Sheringham Shoal and Dudgeon Offshore Wind Farm Extension Projects

Draft Statement of Common Ground with National Highways (Revision B)

Deadline 3

Document Reference: 12.22

▨ VEHICLE BODY SWEEP PATH (FORWARD GEAR)
 — VEHICLE CHASSIS SWEEP PATH

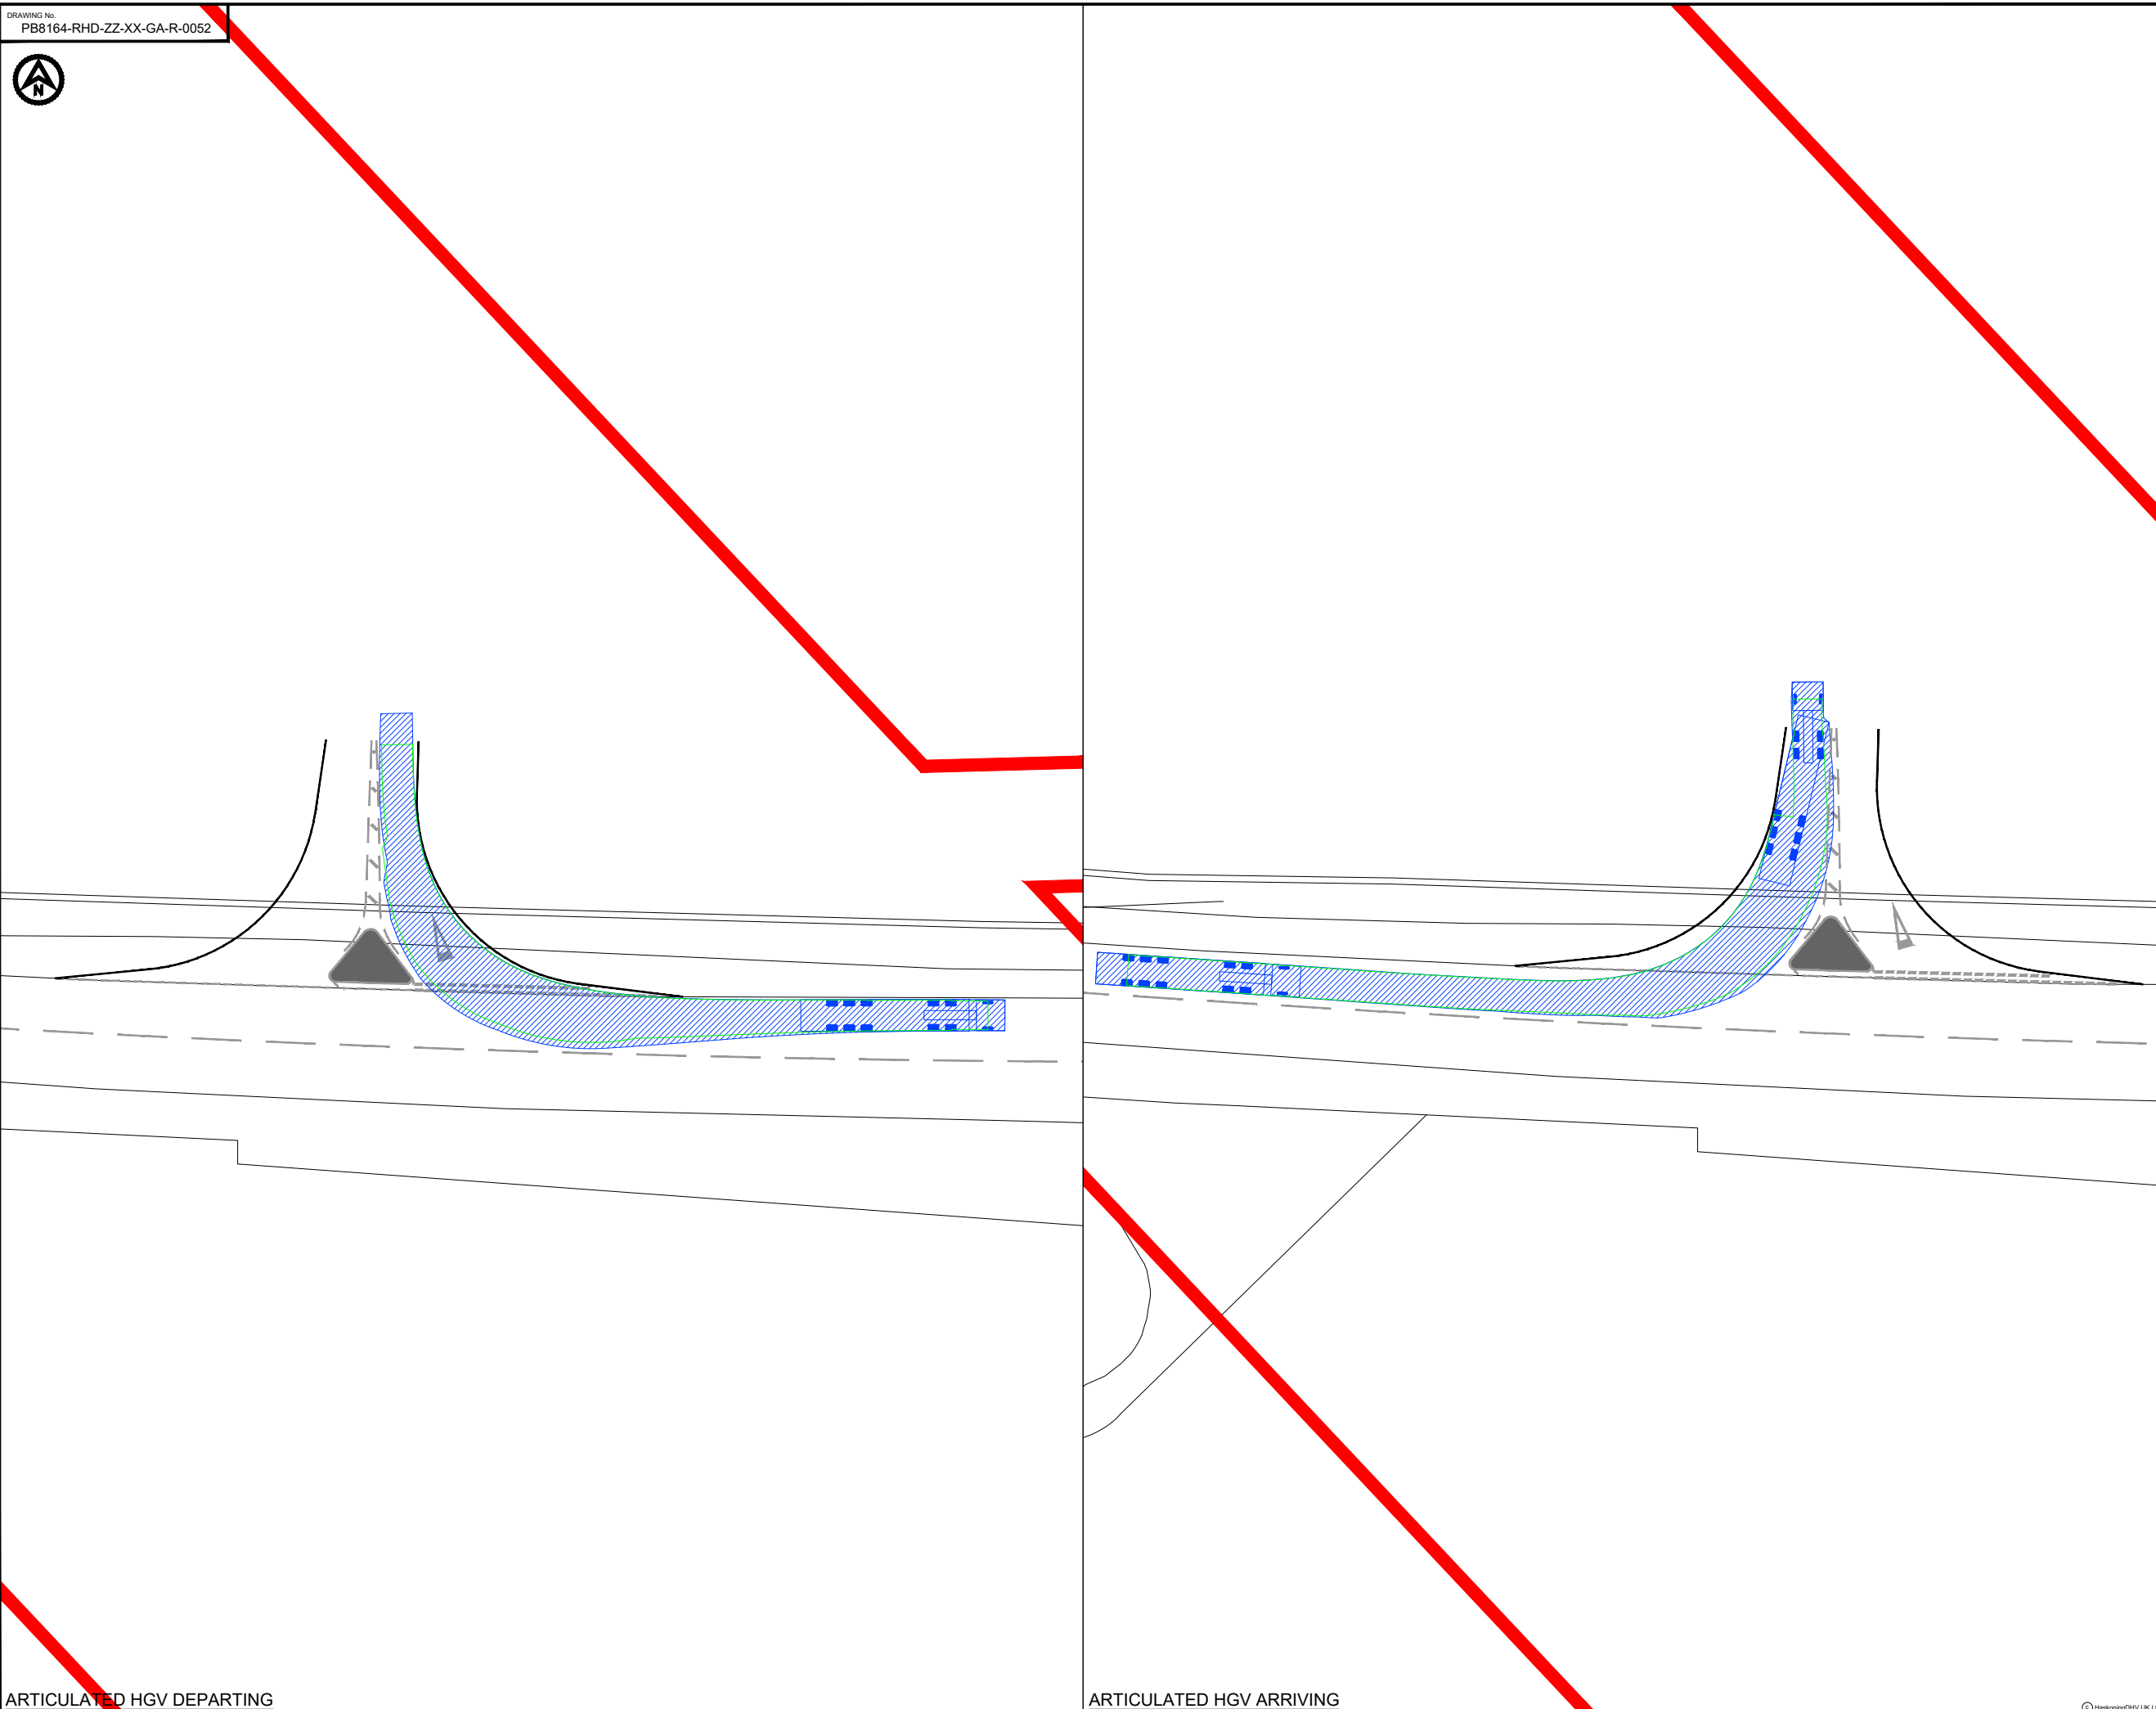
29	The access concept design for access ACC47 is appropriate and that detailed access designs can be developed and agreed with National Highways prior to the start of construction, secured under Requirement 16 of the draft DCO [AS-009].	<i>National Highways agree that the access concept design for access ACC47 is appropriate, subject to a Stage 1 Road Safety Audit to be carried out post consent, and that detailed designs can be developed and agreed with National Highways prior to the start of construction, secured under Requirement 16 of the draft DCO.</i>	Agreed
30	The monitoring procedures set out in the OCTMP [APP-301] are appropriate.	<p><i>The Applicant and National Highways' have agreed that minor amendments are required to the wording in regard to provision of monitoring reports. National Highways' position is therefore reserved pending further review of the amendments to the OCTMP at Deadline 3.</i></p> <p><i>National Highways have requested further amendments to the OCTMP (28/04/2023). The requested amendments would include a monitoring group that is set up and chaired by the Applicant which will consider whether the CTMP is being carried out and working. The monitoring group will include</i></p>	In Discussion
